**Our ref:** AN/2024/135649/01-L01  
**Your ref:** H18-0463-24  
**Date:** 20 June 2024

**Change of use from hotel Class C1 to residential Class C3 including the creating of 15 residential units  
Bridge Hotel, 4 Bridge Road, Sutton Bridge, Spalding, PE12 9UA**

**Environment Agency position**

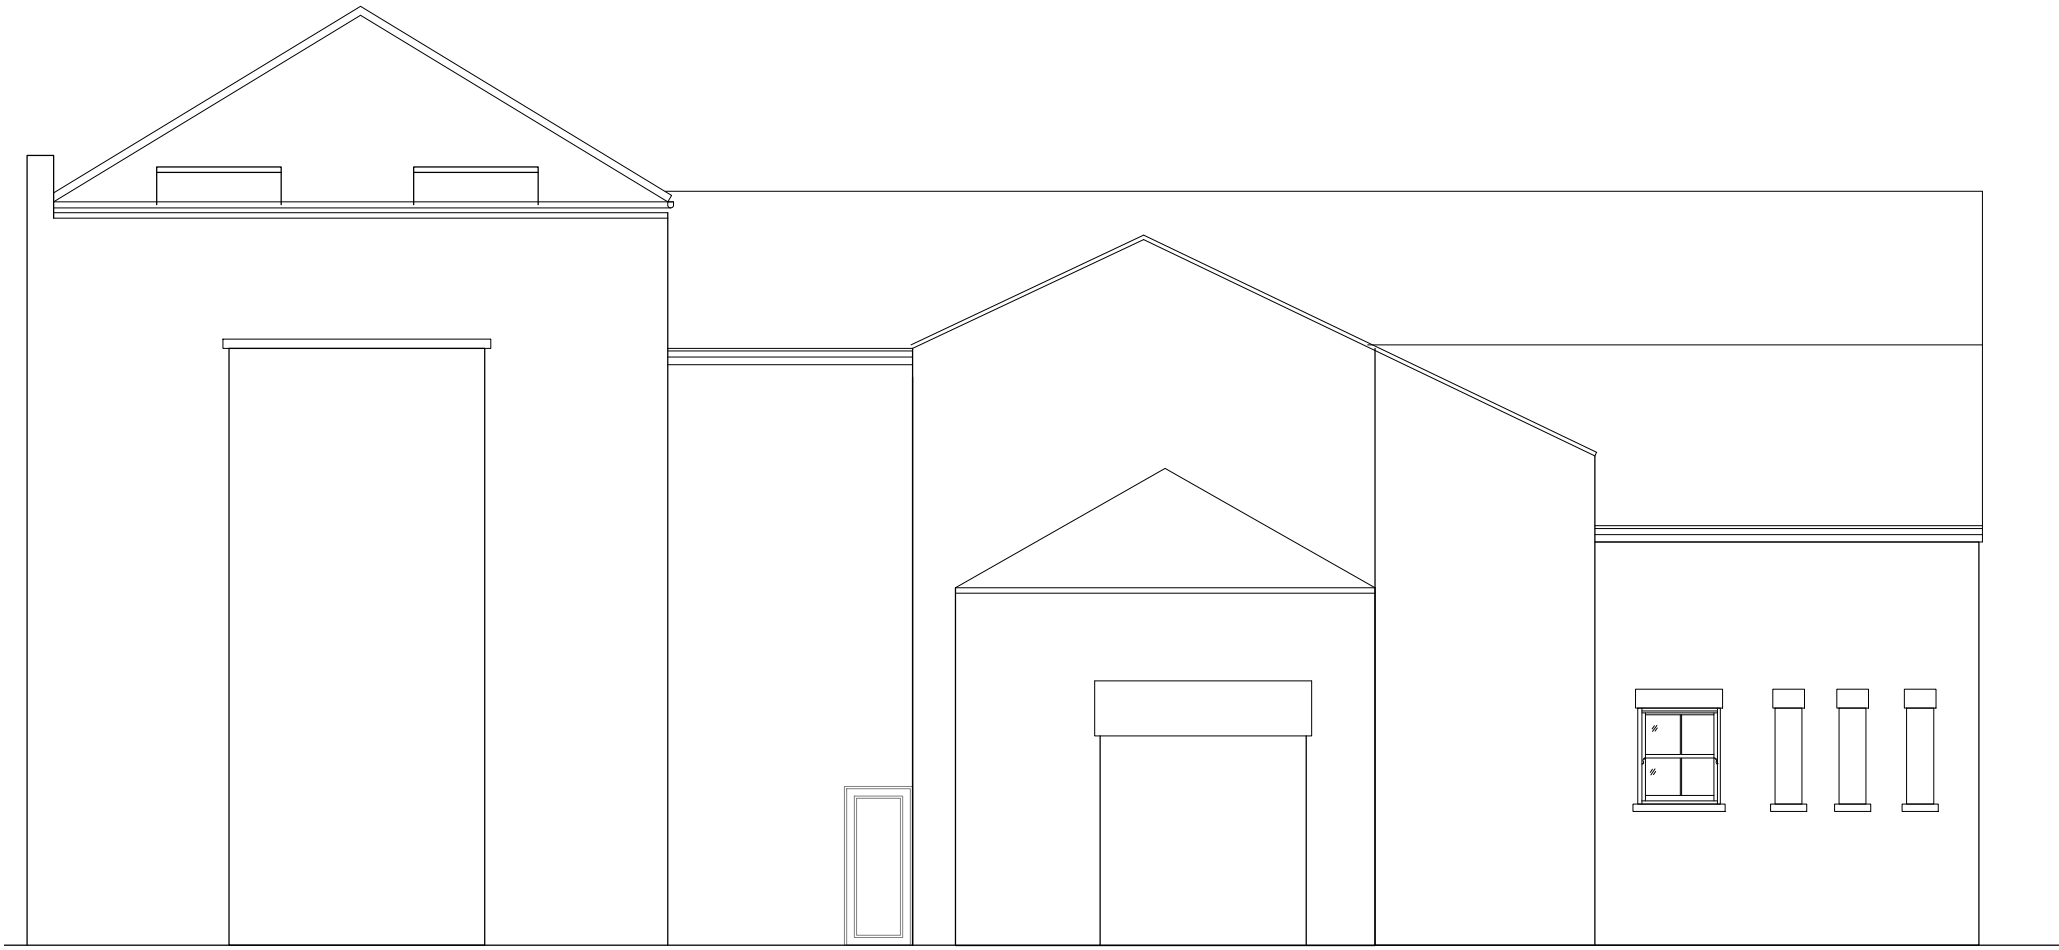
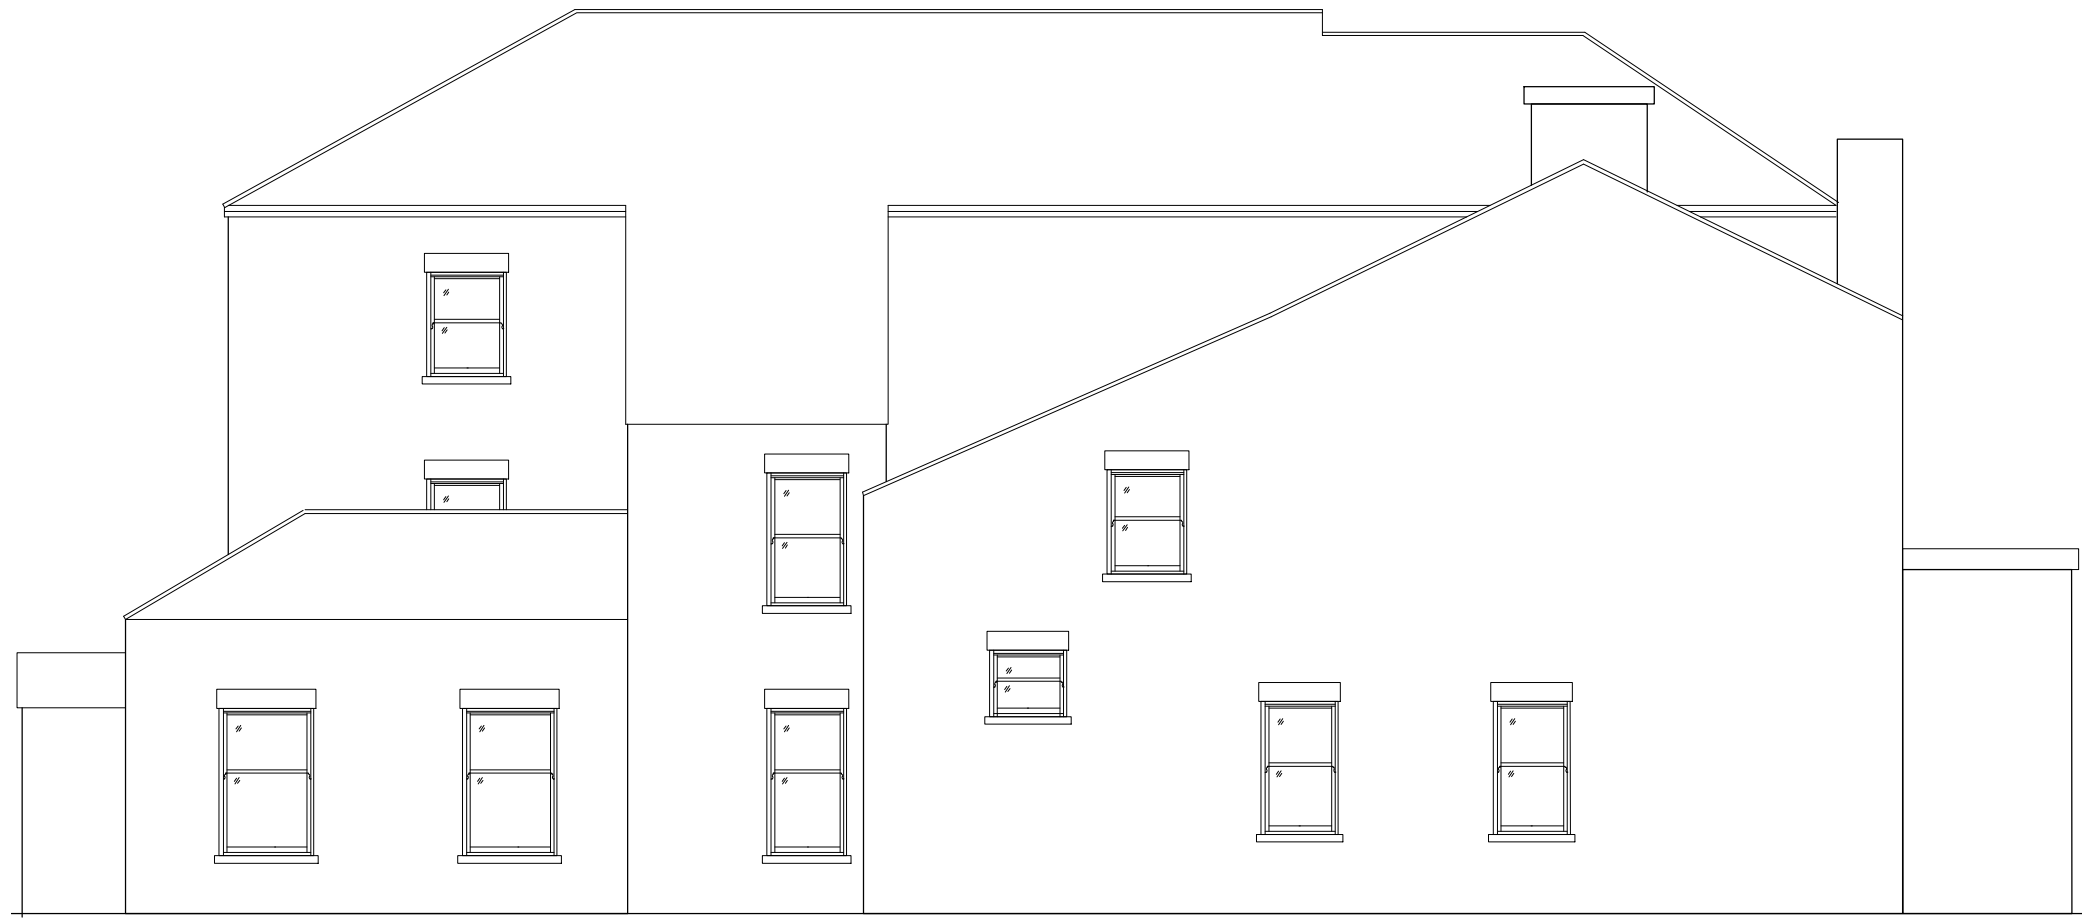
There is also a lack of information on the existing elevations and finished floor levels (FFL) at the site. The submitted drawing dated 26 April 2024, ref: 'Existing Elevations' appears to show that the basement is partially below the existing ground level, which suggests that the ground floor level might be elevated above the existing ground levels. Therefore, further clarification should be provided on the existing FFLs at the site to inform any further assessment of the flood risk. Levels should be provided in metres above Ordnance Datum.
